ExQ1: 18 March 2026 Responses due by deadline 1: 7 April 2026

21. Water Environment

Q21.0.1 The applicants STW Foul drainage capacity

Q21.0.6 The applicants EMG2 works Sustainable Drainage Statement

Figure 1 – Generalised Topography at EMG2 Main Site

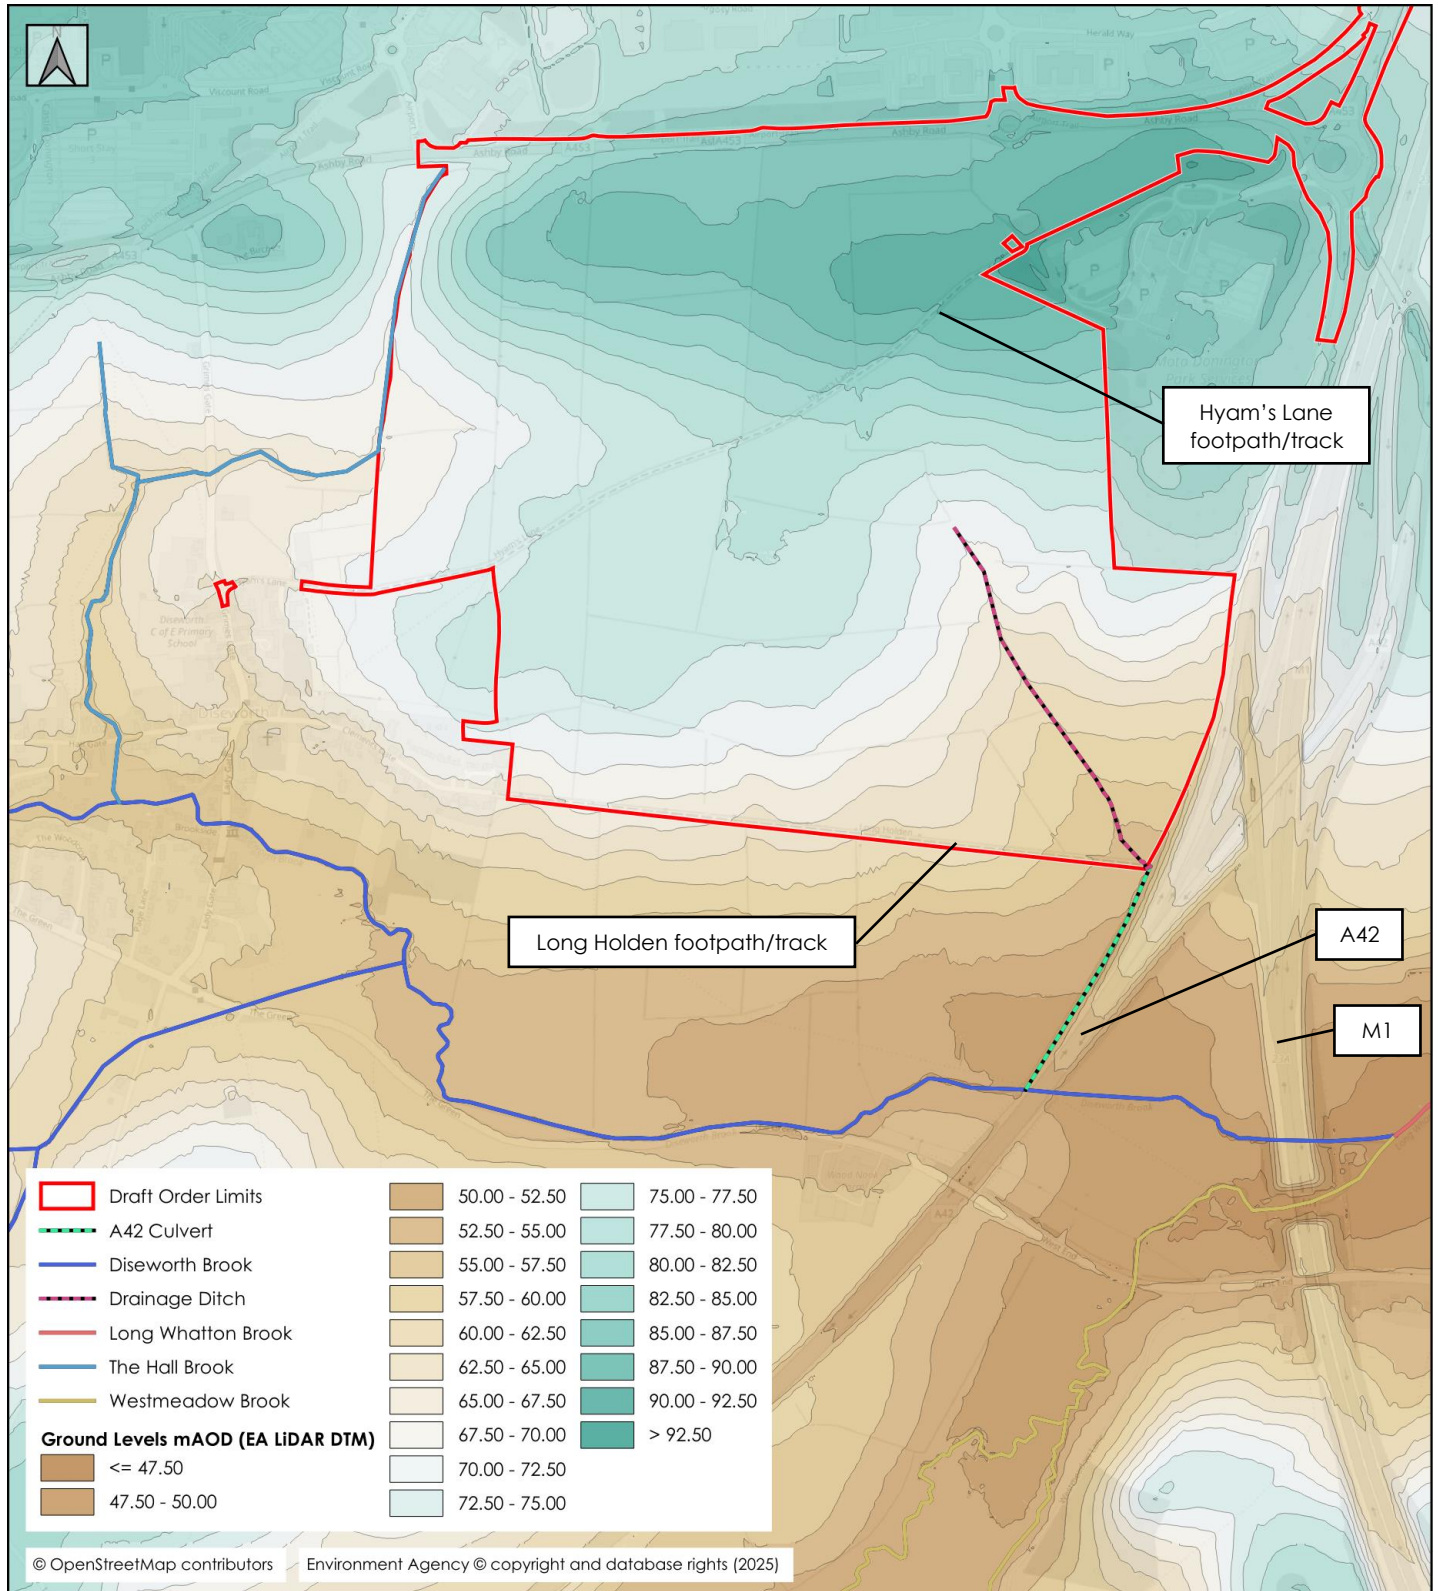
Appendix 6 of the Sustainable Drainage Statement [APP-149] illustrates the concept drainage strategy and that surface water would mainly flow east to west before flowing south and east towards the A42 culvert connection. Please can the applicants explain how the surface water flows would be encouraged in these directions given the intervening bunds and other topographical changes between the EMG2 main site and the community park's attenuation/ detention features?

[PD] Site proposed North/South runoff drainage swales and balancing ponds are sited between Diseworth and 10m high bunds. If there is failure in the drainage system (design flaw, poor maintenance, exceedance storm intensity etc) with topology falling westward, then waters will flow down directly into Diseworth. Has it been considered to move the swales East and the bunds West, so the bunds could offer last line protection in extremis?
